EAST PRESTON PARISH COUNCIL

Date: 15th November 2007

EP/160/07 – Extensions and adaptions for disabled use with carer and family accommodation -
5 Kithurst Close, East Preston

PROPOSED ELEVATIONS

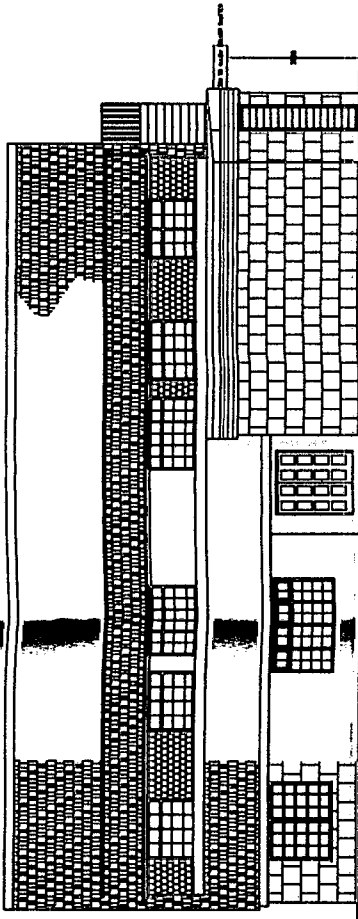
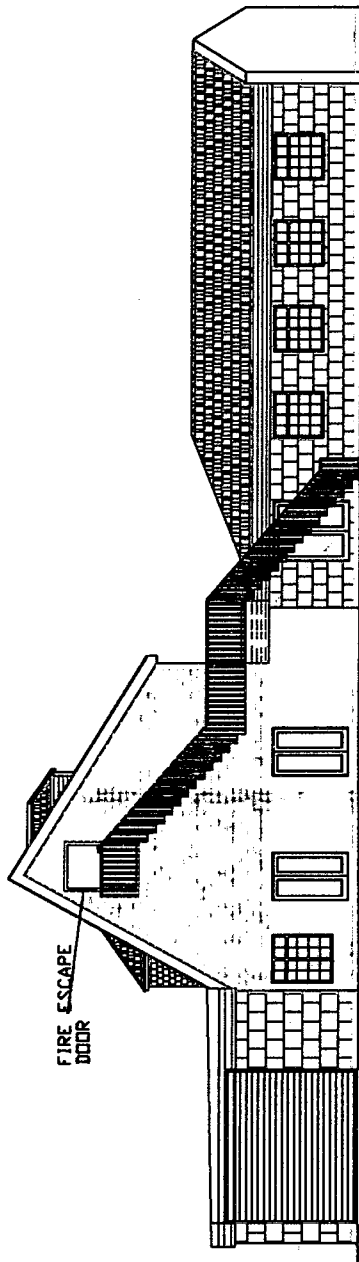
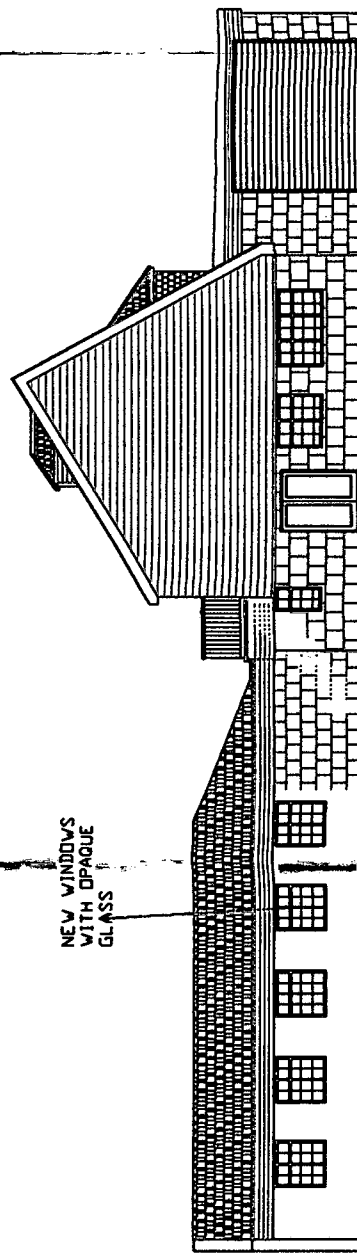
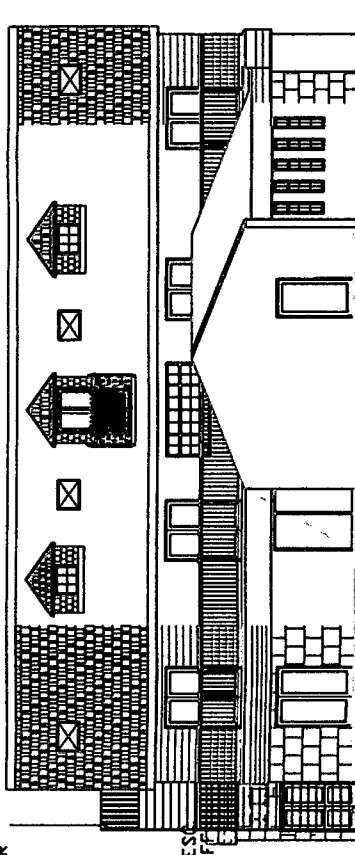
The Committee expressed their concern at the magnitude of the alterations, particularly to the main roof and wish to object to this application on the following grounds:-

1. The Willowhayne Estate is an area of mainly two-storey houses or bungalows built on relatively large plots. Nearly all roads are flanked by verges and there are no footpaths. Any new alteration or construction should be in-keeping with the landscaped setting which is an aspect of this character area.
2. The 2 1/2 storey extensions to the east and west elevations, together with the full length flat roof dormer windows to the second floor roof space, would significantly change and increase the size and appearance of the main roof. The front and rear elevations would be prominent and overbearing and the visual impact would be unacceptably harmful to neighbouring properties and the character and appearance of the area.
3. The existing property is already a substantial building and the proposed alterations would be visually dominant within the street scene and out of character in the area.
